Fire Marshal Division

RE: Afterburner Cigar Lounge
506 W. Front St.
Lillington, NC 27546

Application Number – FMFW2006-0006

A1 LIFE SAFETY PLAN
 SCALE: 3/16" : 1'-0"

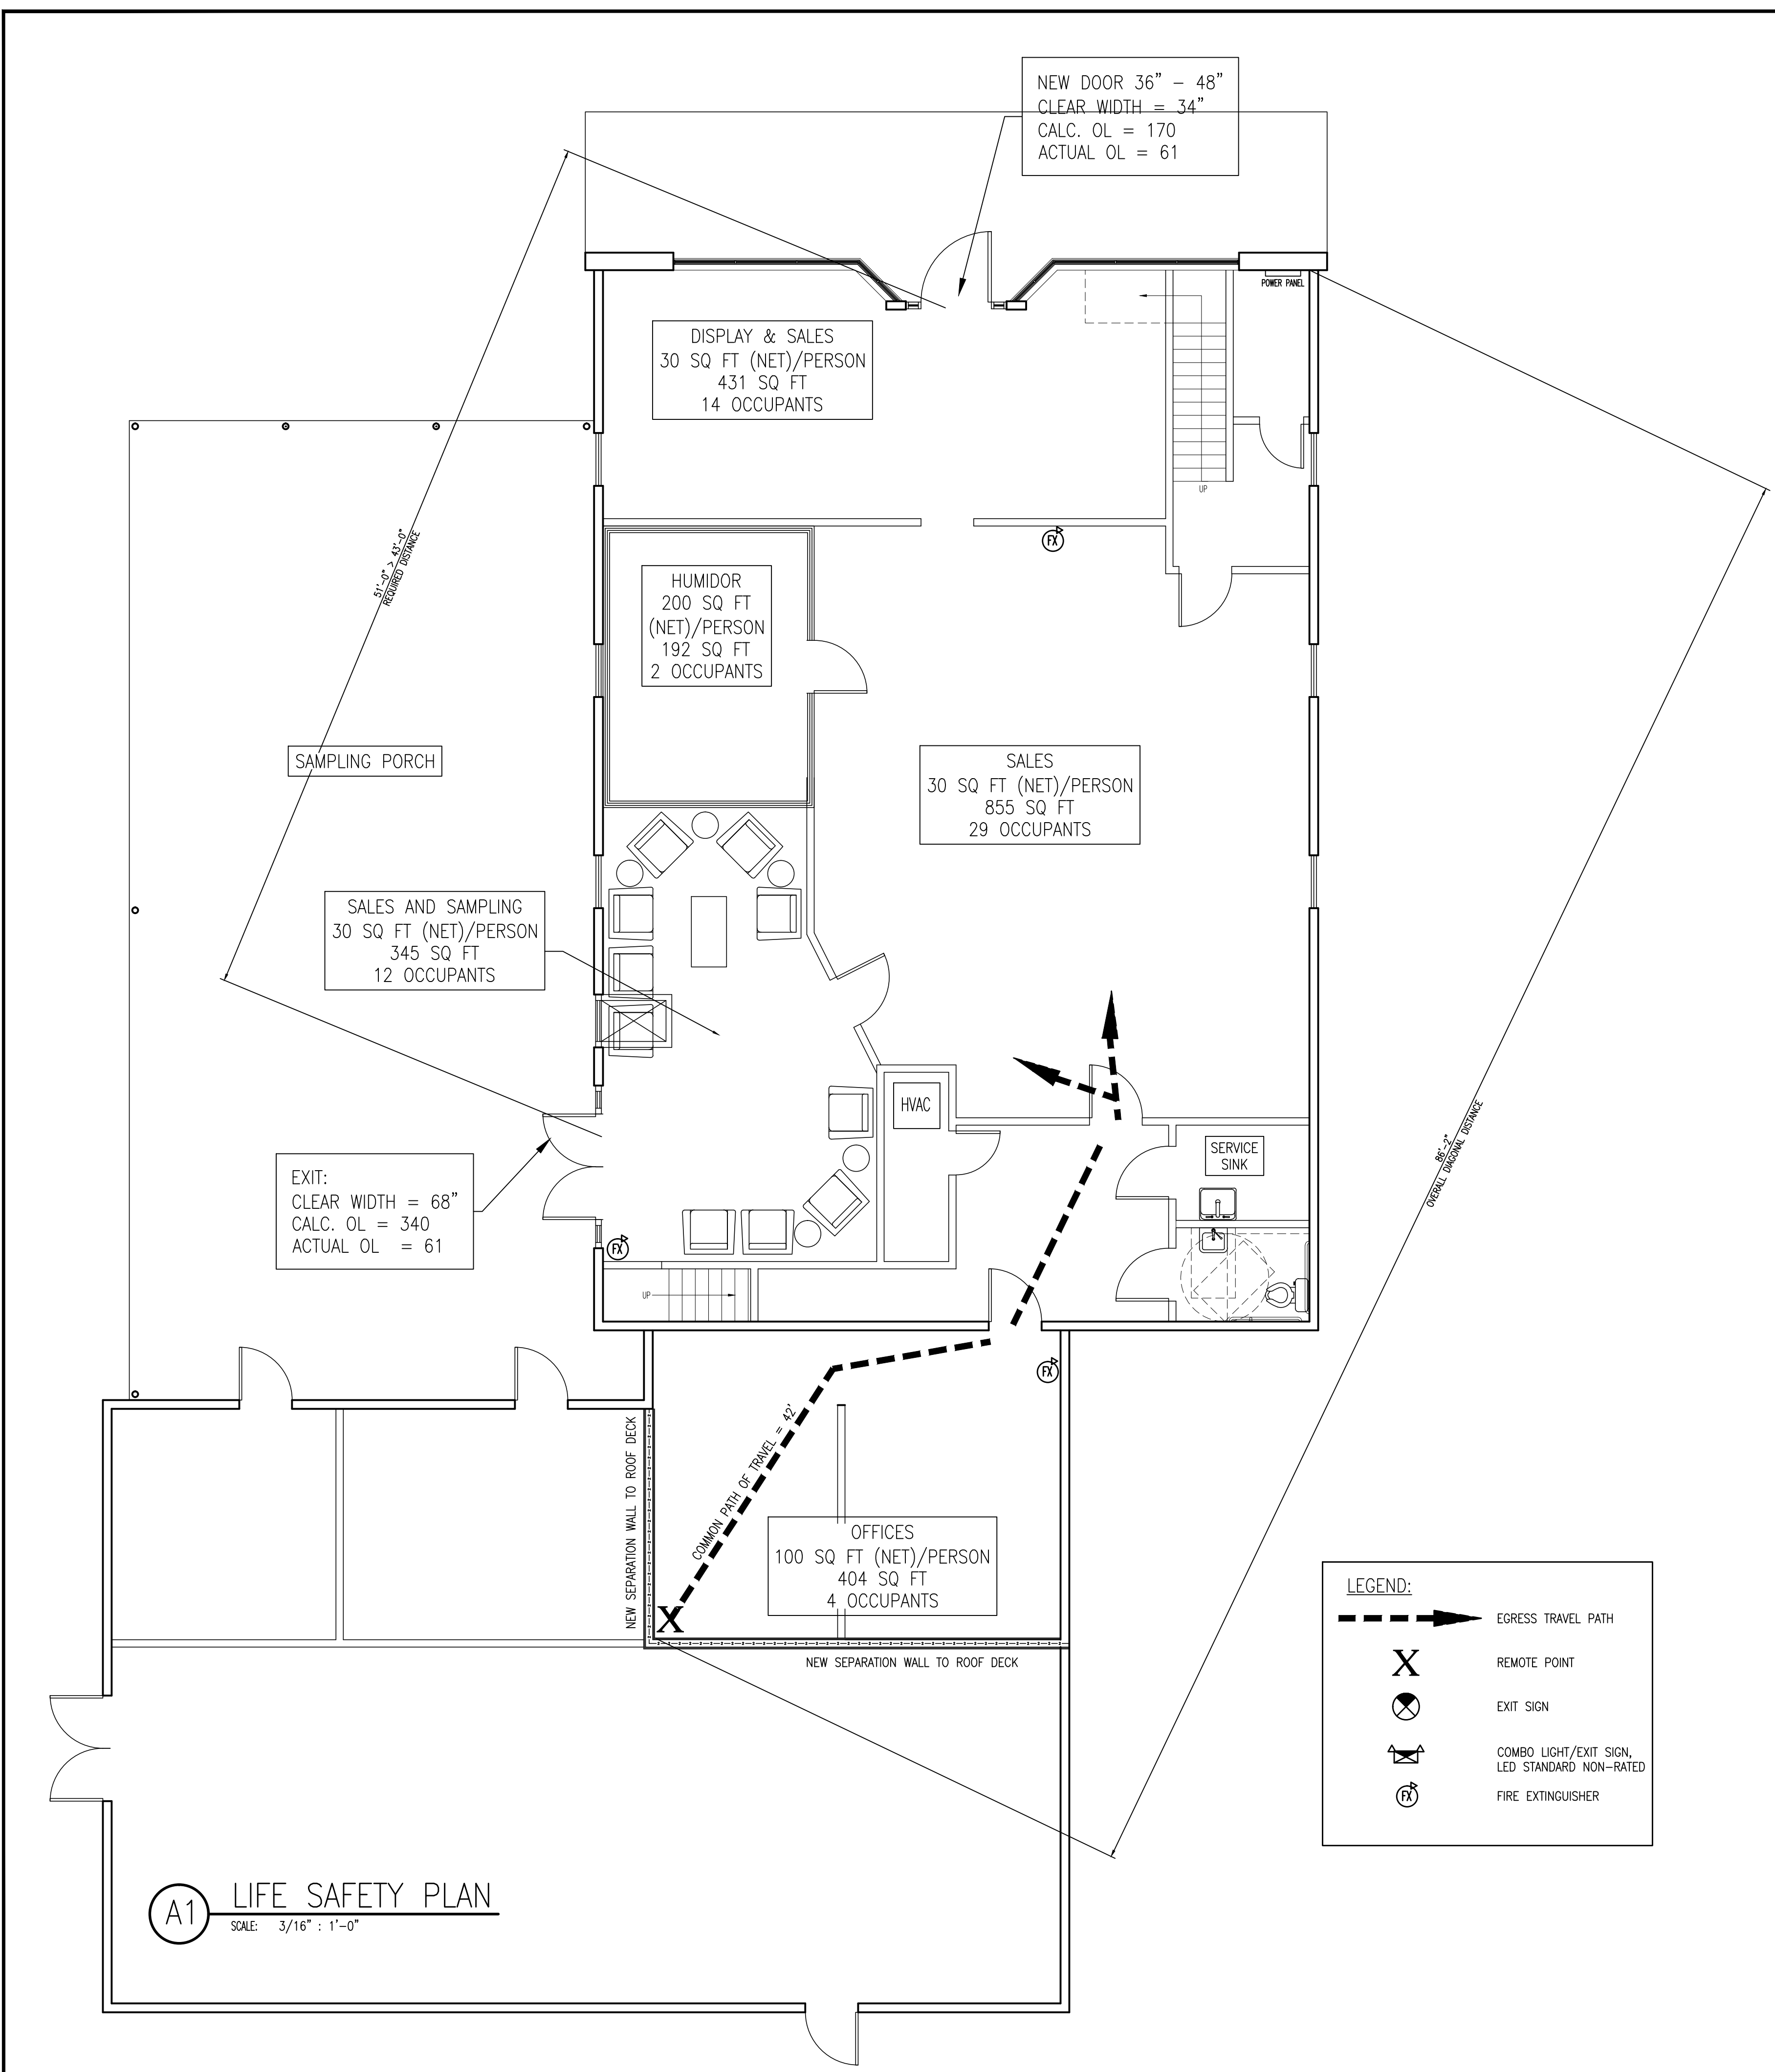
- **Fire Extinguishers**
 - Fire extinguishers shall be placed not to exceed 75' of travel distance.
 - The fire extinguishers provided shall have a minimum rating of 2A 10B: C and shall not be installed higher than 5 feet above the finished floor.
 - In addition to the above extinguishers, a portable fire extinguisher shall be provided within a 30-foot (9144 mm) travel distance of commercial-type cooking equipment. Cooking equipment involving vegetable or animal oils and fats shall be protected by a Class K rated portable extinguisher.

- **Emergency Lighting**
 - All emergency lighting, provided prior to up fit, shall be in proper operating condition at time of final inspection.
 - Any changes made in illumination requirements, due to equipment placement or storage arrangements shall be addressed before final inspection.
 - Emergency lighting is required for exit discharge at all labeled exits.

- **Notes**
 - Occupant load should be calculated according to the NC 2018 Fire Prevention Code.
 - Please note travel distance from most remote point.
 - Please make a note of intent of use for second level
 - Please note the non-separated mixed use assembly area labeled “Sales and Sampling”
